From: Amanda Scholes on behalf of Planning.Responses
Sent: 25 November 2019 13:13
To: Planning Scanning
Subject: FW: Springfield House - R230/19/PL

Please see revised Foul Drainage Drawing. Do you have any additional comments to make? Is it necessary to consult with Southern Water?

In the meantime I note that the Drainage Engineer has made the following comments : It is assumed that the pool is open and not covered. If it is covered then it will need to be accounted for in the Surface Water Drainage Design. This has not been confirmed.

Title			Proposed New Foul Drainage		
Scale	1:500	At original	A4	© Robert Clark Associates Ltd	
Drawing Number	1772/F/SK2		Revision		-

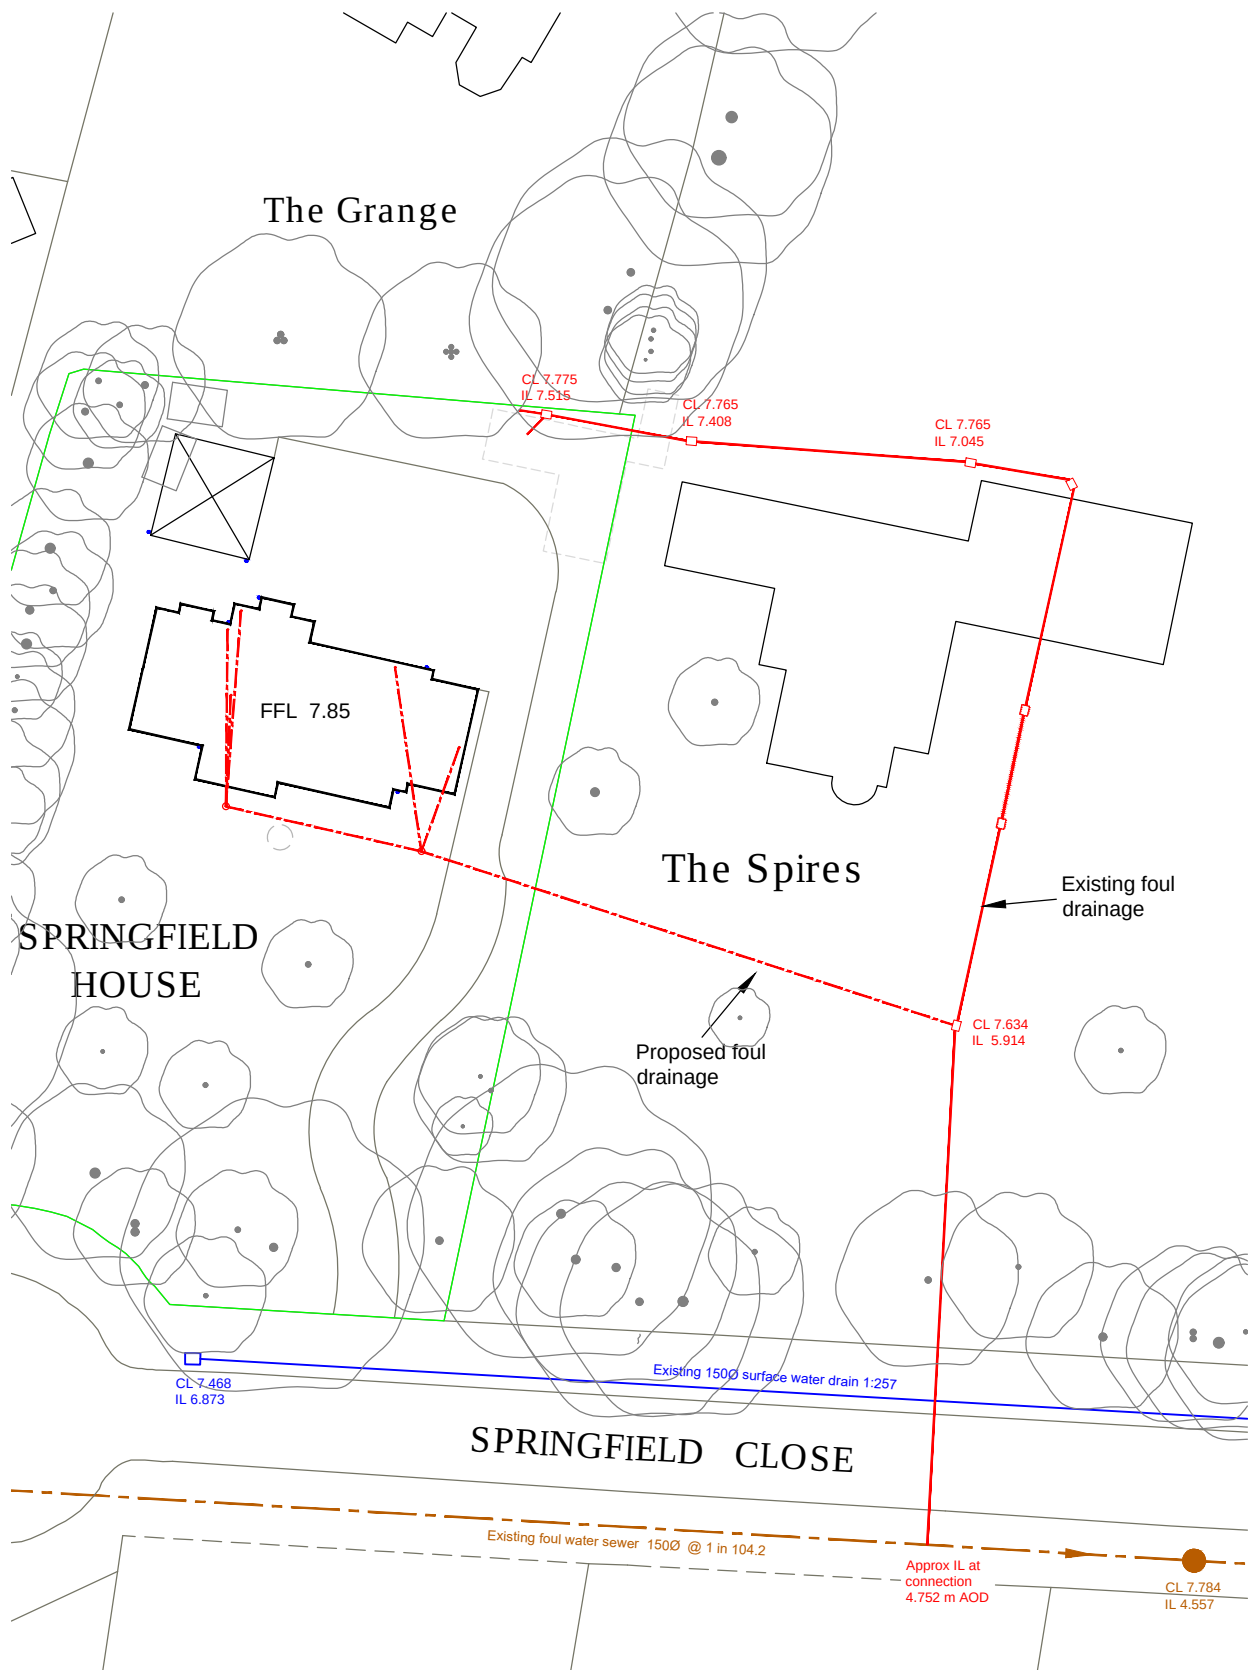
No information is given for how the pool will overflow and backwash. It is assumed that this will go to the foul sewer but this is not shown on the Foul Drainage Drawing. Southern Water will need to be consulted if this is the case. The foul drawing also shows the formally approved 2 bay garage which this application removes. The proposed 3 bay garage is not shown.
